From: Planning
Subject: FW: Consultation on planning application 3/2020/1085 land at Bank Cottages, Whalley Road, Billington BB7 9NL

From: Suds <suds@lancashire.gov.uk>
Sent: 4 January 2021 08:25
To: Planning <planning@ribblevalley.gov.uk>
Subject: RE: Consultation on planning application 3/2020/1085 land at Bank Cottages, Whalley Road, Billington BB7 9NL

The Lead Local Flood Authority (LLFA) has no comment to make on the above application for the following reasons:

Drawing Title
 Proposed Site Plan

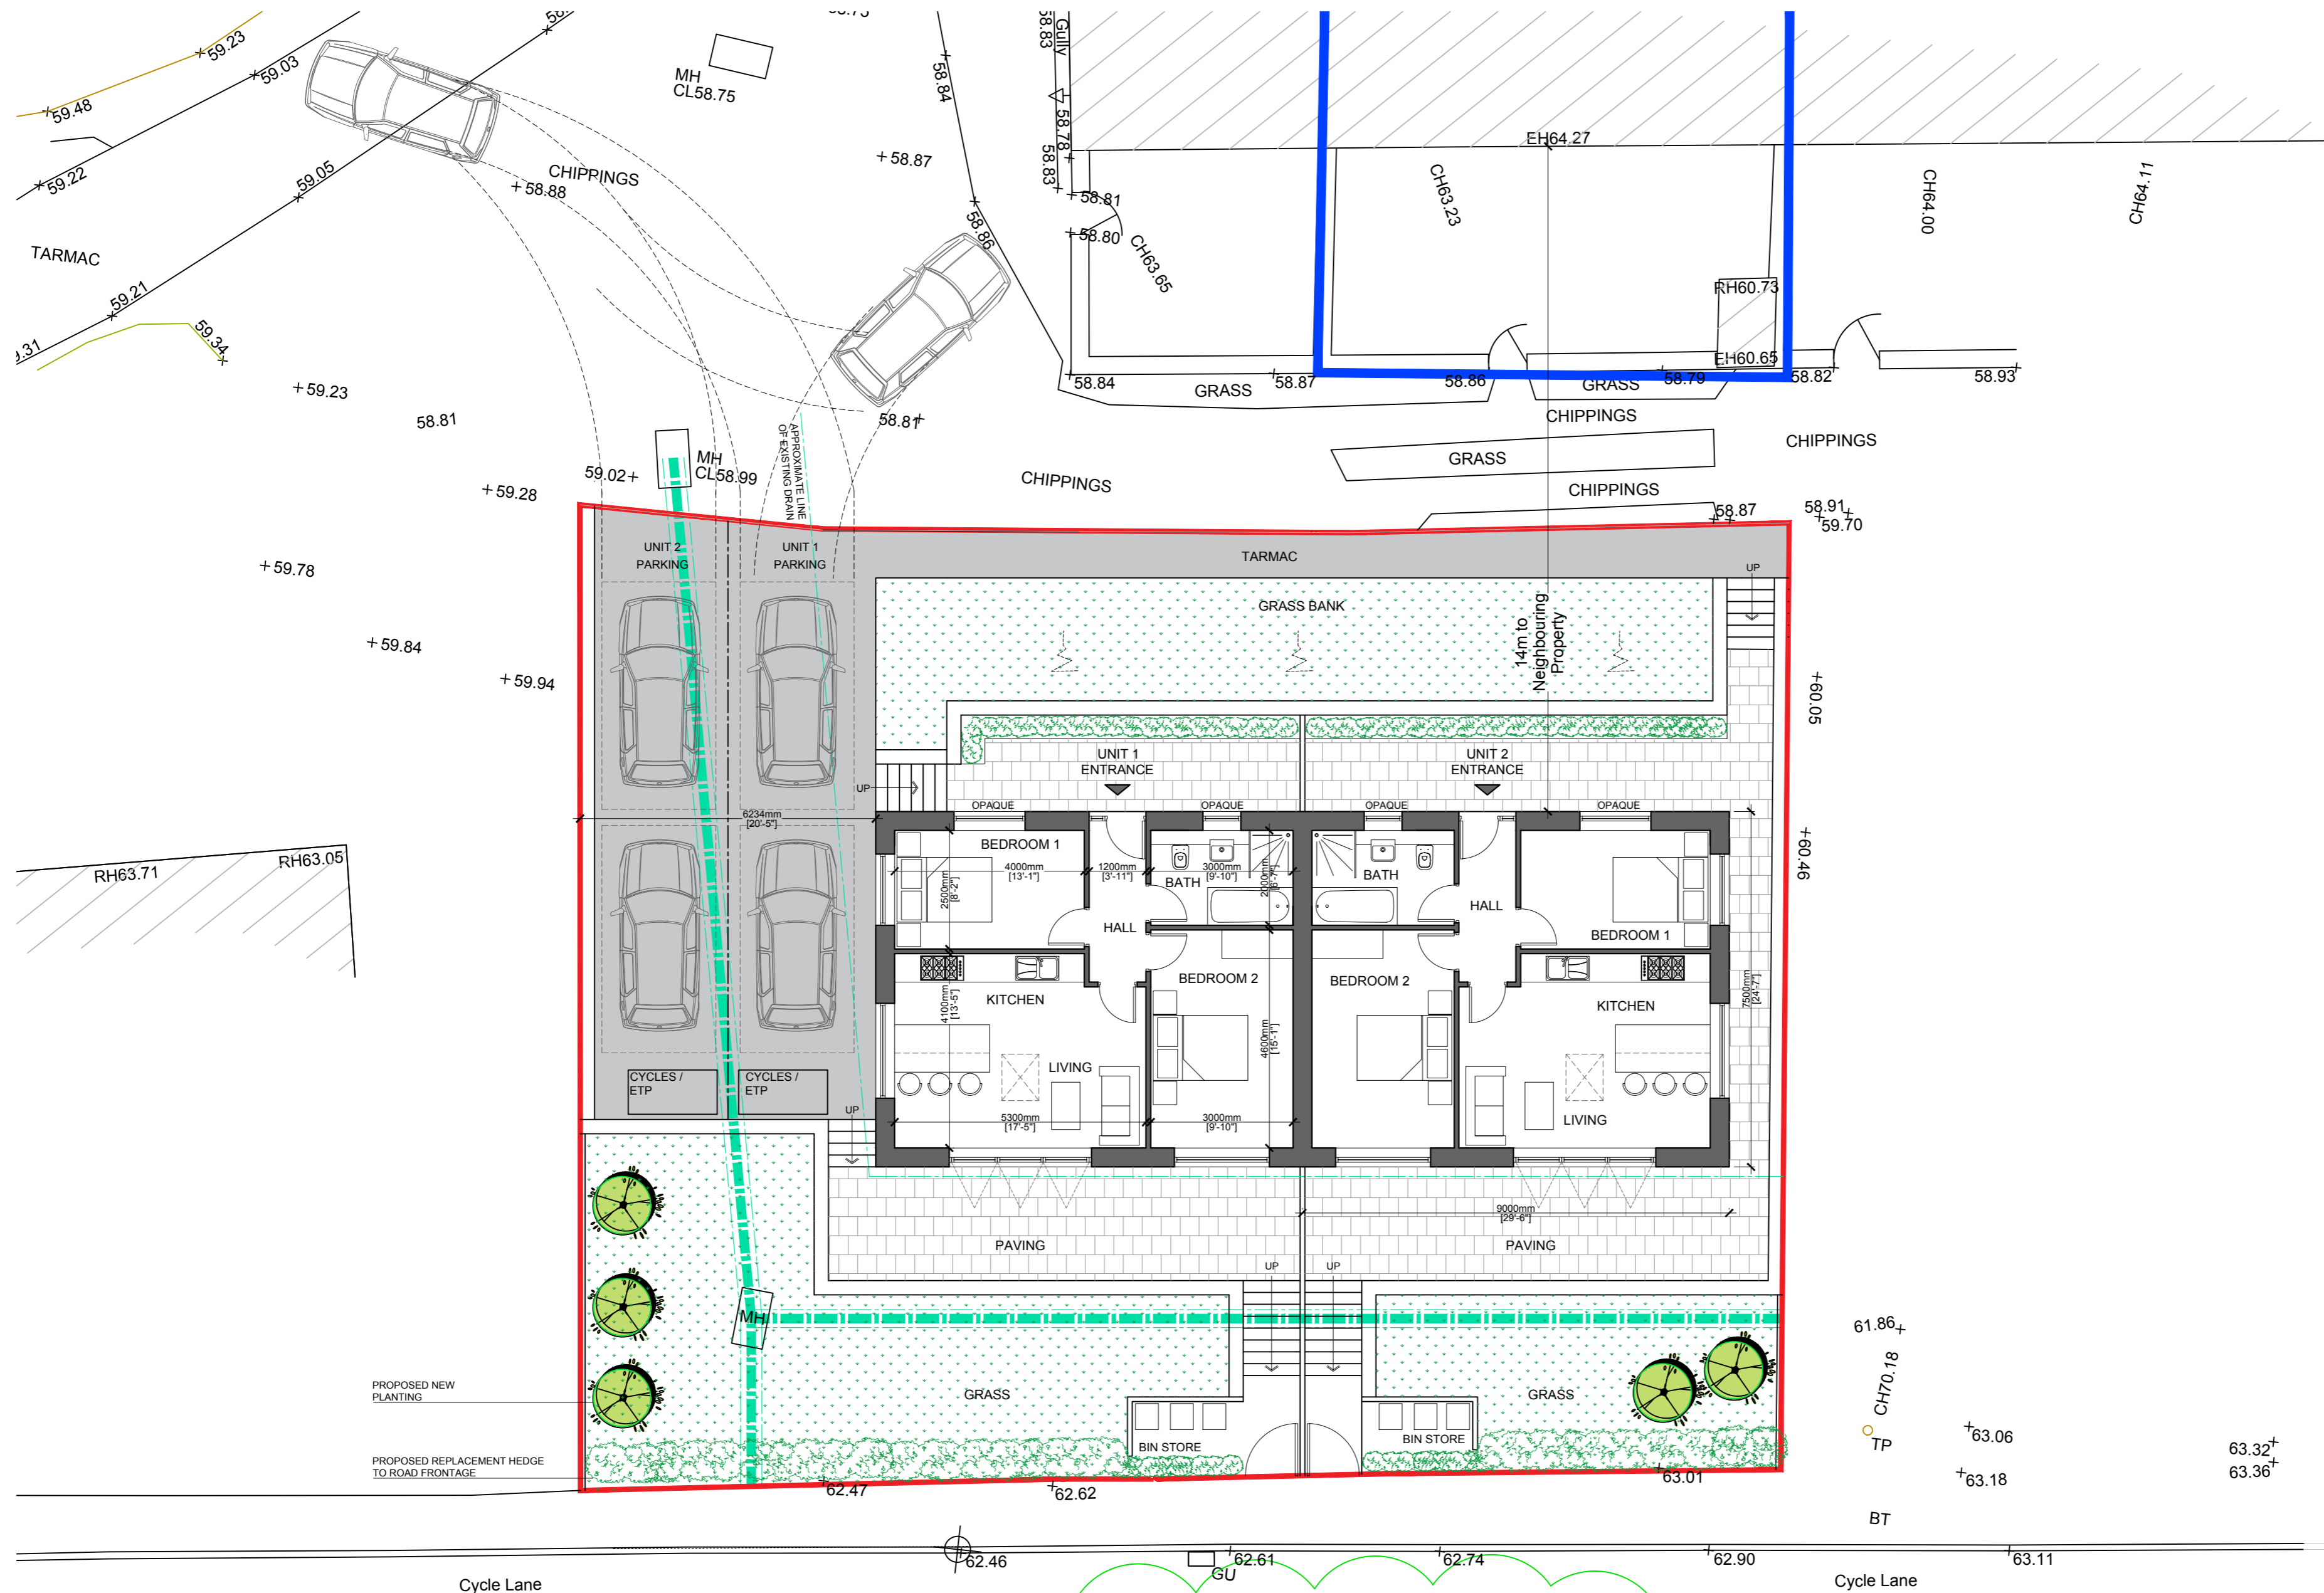
As you may be aware, there is a culverted watercourse that runs east to west through the application site. Construction within 8m of this watercourse is not advised as access for future maintenance purposes could become restricted and it could have the potential to pose an undue flood risk to structures should the culvert ever collapse or should its capacity ever become exceeded.

Under the Land Drainage Act 1991 (as amended by the Flood & Water Management Act 2010), the applicant may need consent from the LLFA should they wish to carry out works to the culverted watercourse. Further information on the land drainage consenting process can be found via the following link: <http://new.lancashire.gov.uk/roads-parking-and-travel/roads/flooding/alterations-to-a-watercourse.aspx>. For the avoidance of doubt, once planning permission has been obtained it does not mean that land drainage consent will be given.
